OBJECTION TO PLANNING AND LISTED BUILDING CONSENT FOR REPLACEMENT WINDOWS, DOORS AND FRONT EXTERNAL WALL (RETROSPECTIVE) (WITHIN A CONSERVATION AREA)

8 GILES STREET, NETHERTHONG, HUDDERSFIELD, HD9 3EF

LPA REF: 2025/91763 & 2025/91764

Elevations as Existing

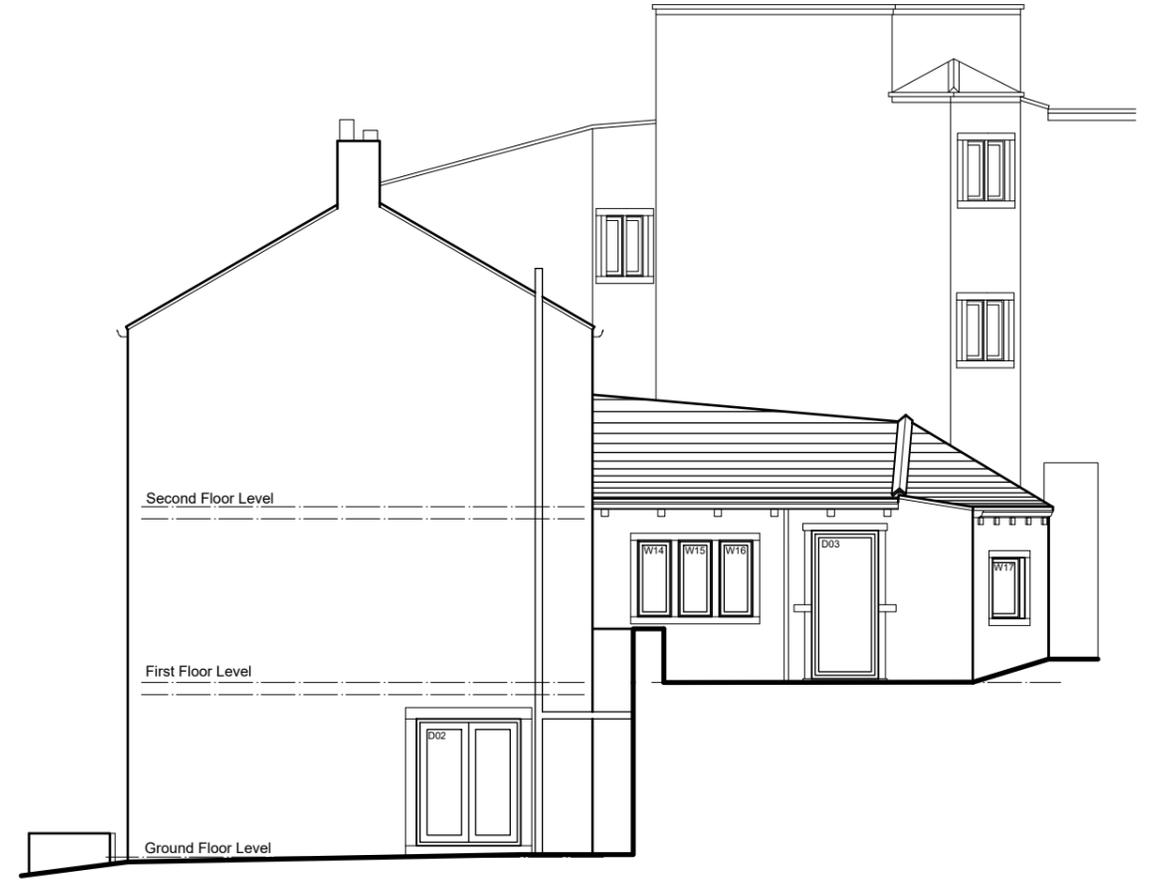
Whilst the replacement of the windows and doors may have been necessary due to decay / general wear and tear, there is no reason why the applicants could not have replaced them like for like i.e. timber for timber. The previous owners' replacements were like for like and Grade II listed approved.

Although the previous timber windows may not have been as high quality as the original windows in terms of design and overall appearance, the previous owners did at least replace the original windows with timber windows. The applicants therefore had an opportunity to improve and enhance the appearance of the listed building by re-installing high quality timber windows that more closely reflected the originals. Instead, grey uPVC windows and doors were installed which has caused harm to the significance of the designated heritage asset.

Use of UPVC Map

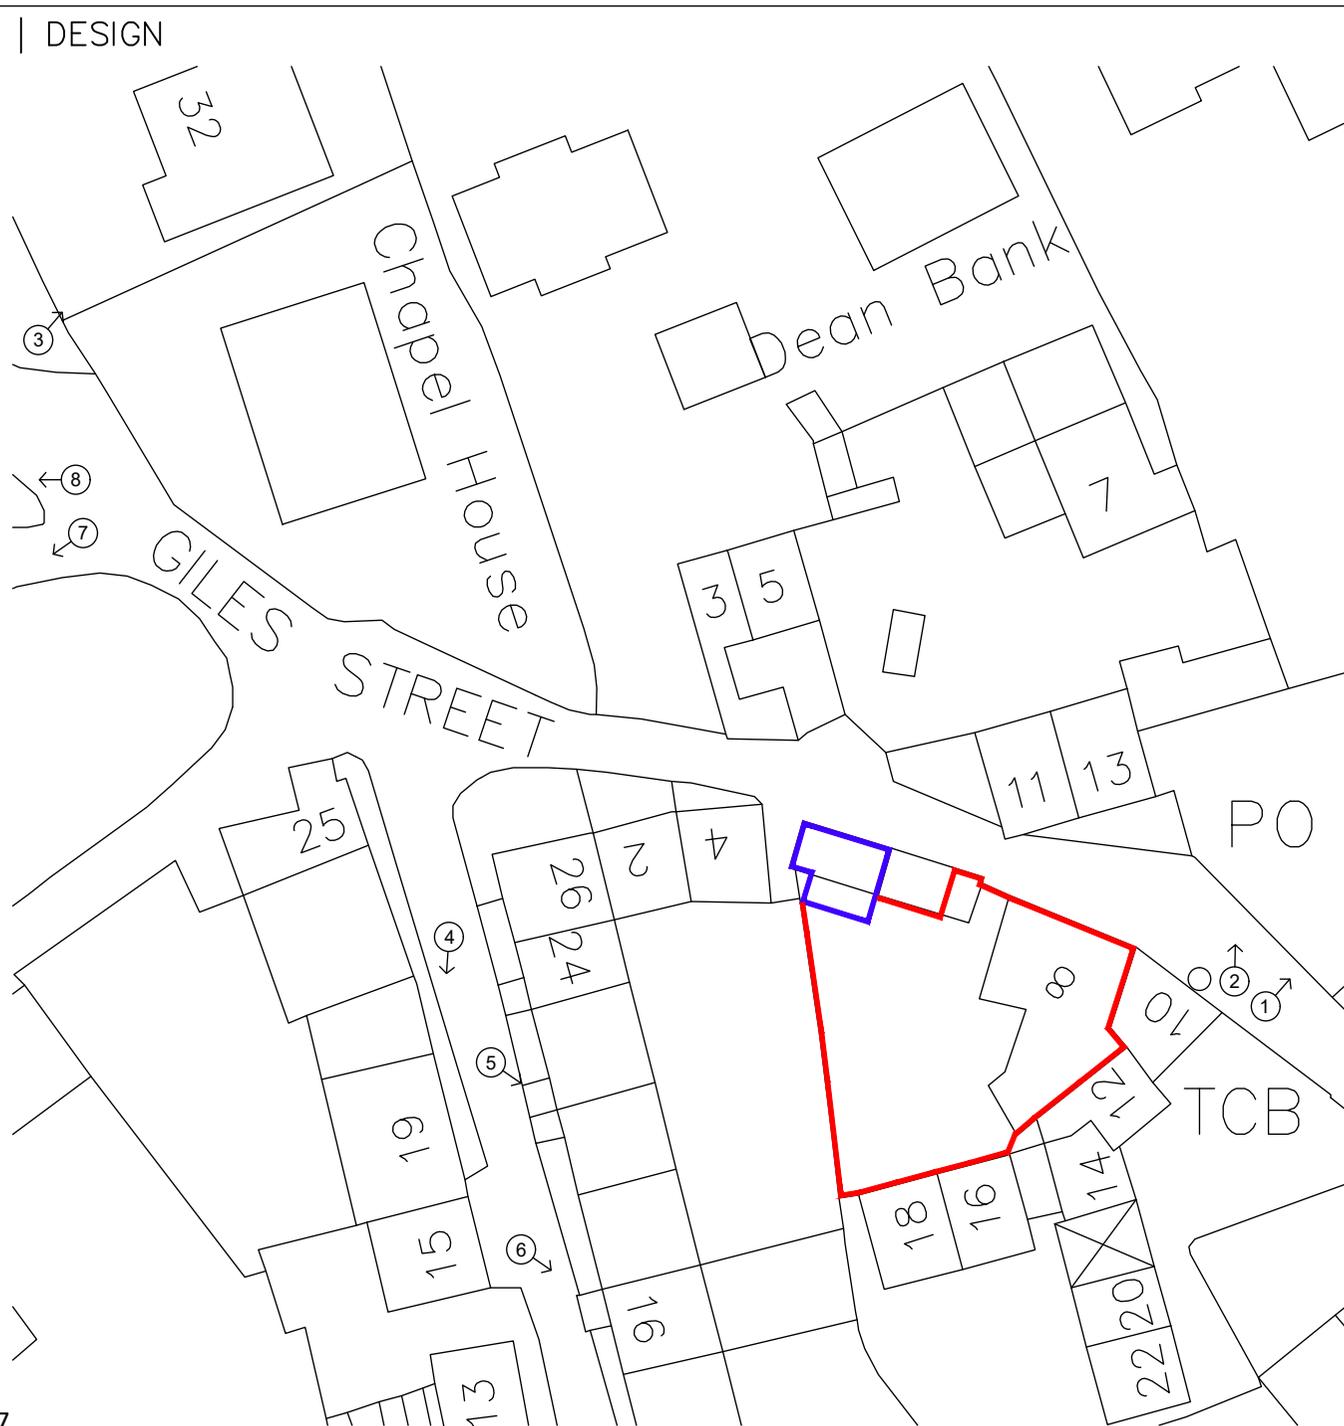
The applicants' list of example buildings with uPVC windows in Netherthong shows just one on Giles Street – number 15 (the old Post Office) – which is not a Grade II listed building. Numbers 1, 2, 3-5, 4, 6 (which is the former store converted by the applicants under LPA ref: 2019/62/91806/W by the applicants), 7, 10, 11-13 all have wooden windows and can be viewed along the road – 8 out of 10. Therefore, 8 is one of two outliers, when it should be the model of the character in the conservation area, it being the only listed building on the road.

The applicants have taken the remainder of their uPVC image examples mostly from Out Lane, ignoring the 4 Grade II listed properties on this road, which all have wooden windows (5, 7, 15; and Whig Cottage, 11, having upgraded its wooden windows via planning consent on LPA Ref: 2022/65/91383/W "Listed Building Consent for installation of replacement windows (within a Conservation Area)").
